PLANNING AMENDMENT

APPLICANT NAME AND ADDRESS Mr and Mrs C. Wilson 16 Thorpe Avenue, Moulton Chapel, Spalding, Lincolnshire, PE12 0XN. Telephone: 07793 452783 / 07989696888	AGENT NAME AND ADDRESS Telephone:
SITE ADDRESS DETAILS 16 Thorpe Avenue, Moulton Chapel, Spalding, Lincolnshire, PE12 0XN.	
CURRENT APPLICATION NO: This amendment cannot be considered unless the relevant reference is stated.	H13-0221-20
Building Regulation reference relating to same development (if applicable)

FULL DESCRIPTION OF DEVELOPMENT OF CURRENT APPLICATION THAT THIS AMENDMENT RELATES TO	Two storey side extension and single storey rear extension replacing existing conservatory.
--	--

AMENDED PROPOSED GROUND FLOOR 16 THORPE AVENUE, MOUTON CHAPEL,
SPALDING, PE12 0XN 1cm=500mm

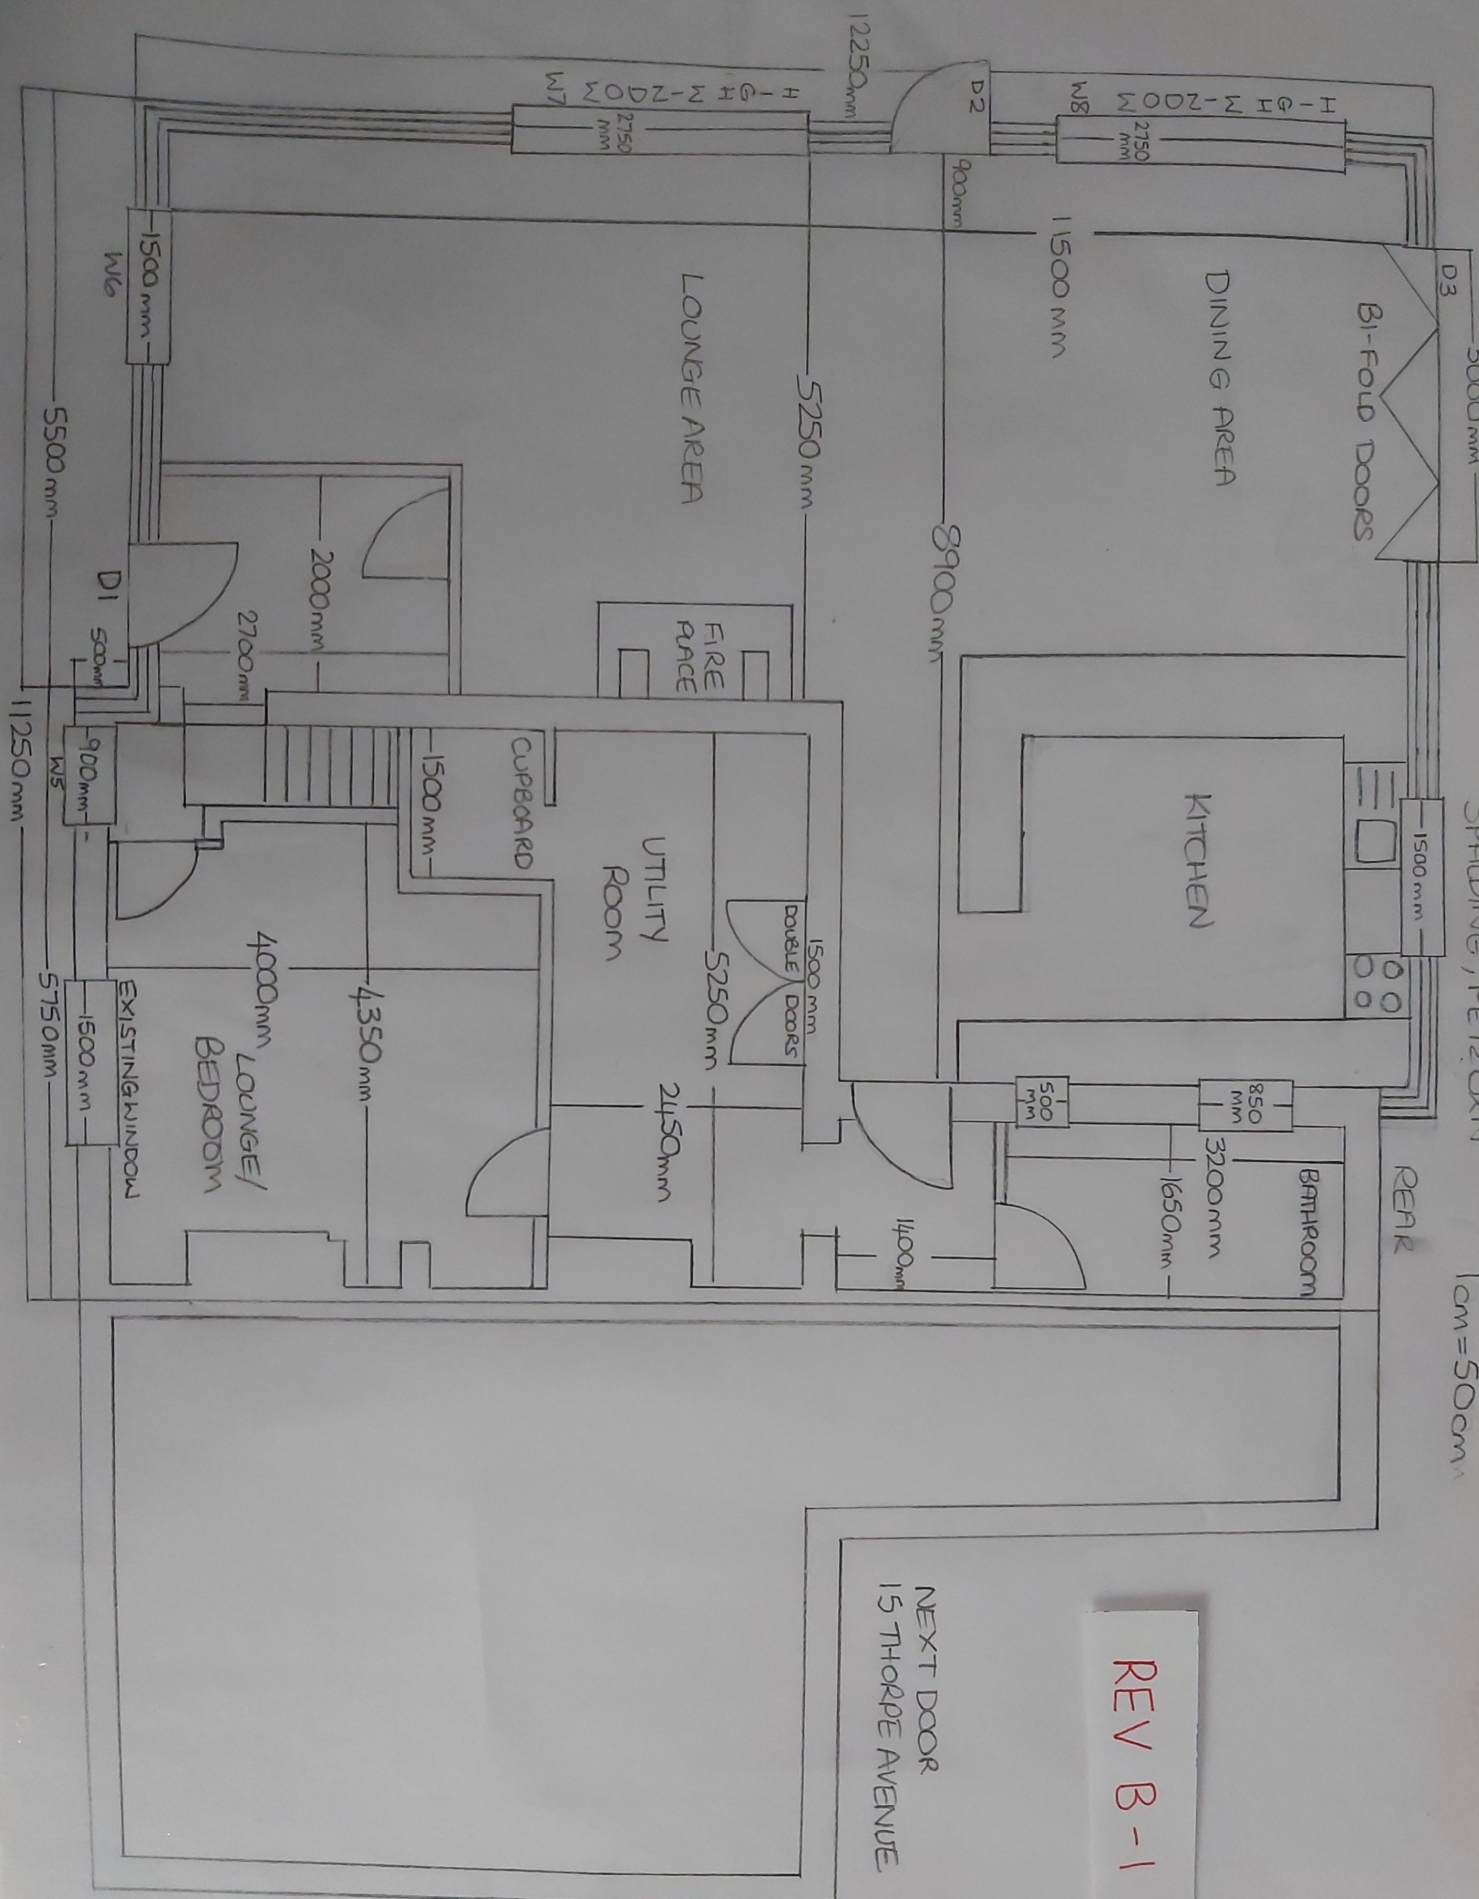
State details of amendments proposed. (Give a full detailed list of the changes, and also mark these clearly on the accompanying plans. Only the changes listed here will be considered)	1. Front wall of extension taken back 50cm so that it sits back from front wall of original house as requested. 2. Back wall of extension moved back 50cm to allow for amendment 1. 3. Ridge of roof of extension lowered as requested.	
State drawing numbers of the current submission	1. Amended proposed ground floor 2. Amended proposed first floor 3. Amended proposed elevations 4. Amended block plan to show drainage	
Has this amendment been requested by the Council? (If so, state Officer dealing with the application)	YES/NO	Yes, Joan Isus
Describe any part of the original development which is excluded by virtue of the amendment, and state any alteration to plot numbers		
Has a similar amendment been submitted under Building Regulations? (If so, state Building Control Surveyor dealing with application)	YES/NO	No
